Tween Bridge Solar Farm

8.2 Applicant Response to S51 Advice – Covering Letter Nov 2025

Planning Act 2008 – Response To Advice Following Issue Of Decision To Accept The Application For Examination (Section 51 Advice)

Application Reference: EN010148

Figure 2.3: Heights Parameters Zonal Plan

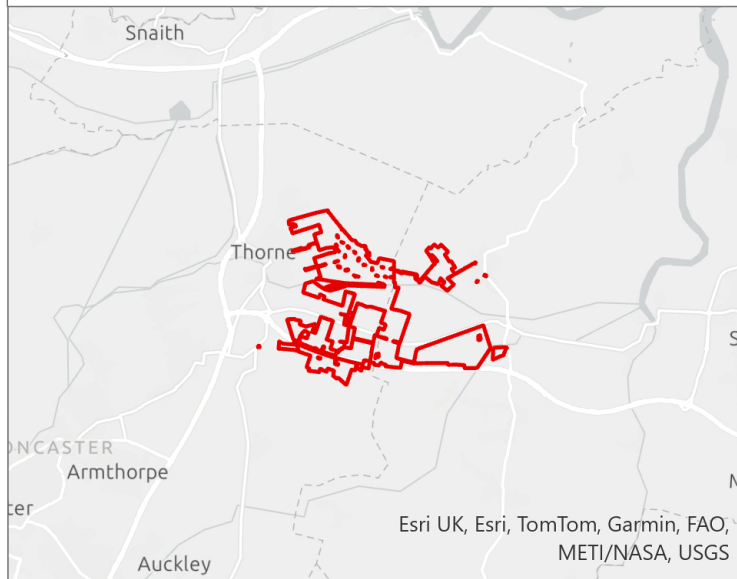
<p><u><i>Maximum Heights and Flood Level</i></u></p> <p>Whilst the maximum dimensions of the solar panels are expressed, the maximum height of the mounting structures is not. The document (page 5) states in part:</p> <p><i>‘The mounting structures will be fixed to the ground by galvanized steel or other material poles which are typically driven into the ground to a maximum depth of 3m’</i> (emphasis added).</p> <p>This needs to be addressed (tightened up). The implications for any requirement for raising panels above flood levels should be fully taken into account and assessed in the relevant ES chapters.</p> <p>It is noted that the Design Parameters Document also states in part:</p> <p><i>‘Solar PV modules which are affected by simulated fluvial flooding will be raised to mitigate against fluvial flood risk. All proposed solar panels and associated infrastructure within the Order Limits will be raised above the modelled 1 in 1,000 year fluvially dominated flood levels on site plus a 100mm allowance for freeboard.’</i></p> <p>It would be beneficial if the applicant could produce a colour coded plan showing maximum panel, solar station, substation and BESS heights across the order limits based on 1 in 1000 flood levels. It is noted that FRA Appendices F and G include data for 1 in 1000 flood levels (+ 100mm freeboard). However, the applicant should provide a similar plan for each component (solar, BESS etc) of the development showing maximum heights. The applicant should consider linking this plan to the Design Parameters Document and should ensure that</p>	<p>The term ‘typically’ has been removed from the Design Parameters and Principles for Work No.1 (Ground Mounted Solar Photovoltaic Generating Stations) to provide a maximum depth of 3m.</p> <p>The Applicant has provided a Figure that has been appended to the Parameters Design Document [Document Reference 5.6.1] to show the heights of the infrastructure within the Order Limits and also the 1 in 1000 flood levels (+100mm freeboard). The Applicant also confirms that the maximum heights of the infrastructure shown in the Parameters Design Document has been assessed within</p>

<p>these maximum heights are reflected in the worst-case scenario assessment for each respective ES topic.</p> <p><u>Solar station locations</u></p> <p>The Design Parameters Document (page 7) states in part as follows:</p> <p>‘Inverters will be located a minimum of 300m from existing sensitive residential receptors unless it can be demonstrated to the satisfaction of the Host Authorities that the location of inverters within 300m of existing residential receptors, would not give rise to materially new or materially different noise effects compared to those reported within ES Chapter 13 Noise and Vibration [Document Reference 6.2.13].’</p> <p>The applicant should consider how the DCO would facilitate this in practice and whether the worst-case scenario assessments for each ES topic take account of the potential for inverters to be located closer than 300m to ‘sensitive residential receptors.’ In addition, the definition of ‘sensitive’ residential receptor applied to the assessment should be provided. Alternatively, the applicant should consider referring to ‘residential receptors’ as opposed to those that are ‘sensitive’ to remove subjectivity.</p> <p><u>Electrical Cabling</u></p> <p>The Design Parameters Document (pages 8 and 9) refers to maximum and minimum figures for the depths of electrical cabling. In each case a caveat is included which outlines that final dimensions will be subject to ground conditions, up to the maximum figures. However, this would appear to allow for cable depths shallower than the minimum figures. It is recommended that</p>	<p>the Environmental Statement Aspect Chapters [Document Reference 6.2.6-6.2.18]</p> <p>The term ‘sensitive’ has been removed from the Design Parameters and Principles for Work No.1 (Ground Mounted Solar Photovoltaic Generating Stations).</p> <p>The Design Parameter and Principles for Work No. 2 (Electrical Underground Cabling) has been amended to include the minimum cabling depths within the caveat for ground conditions during construction.</p>
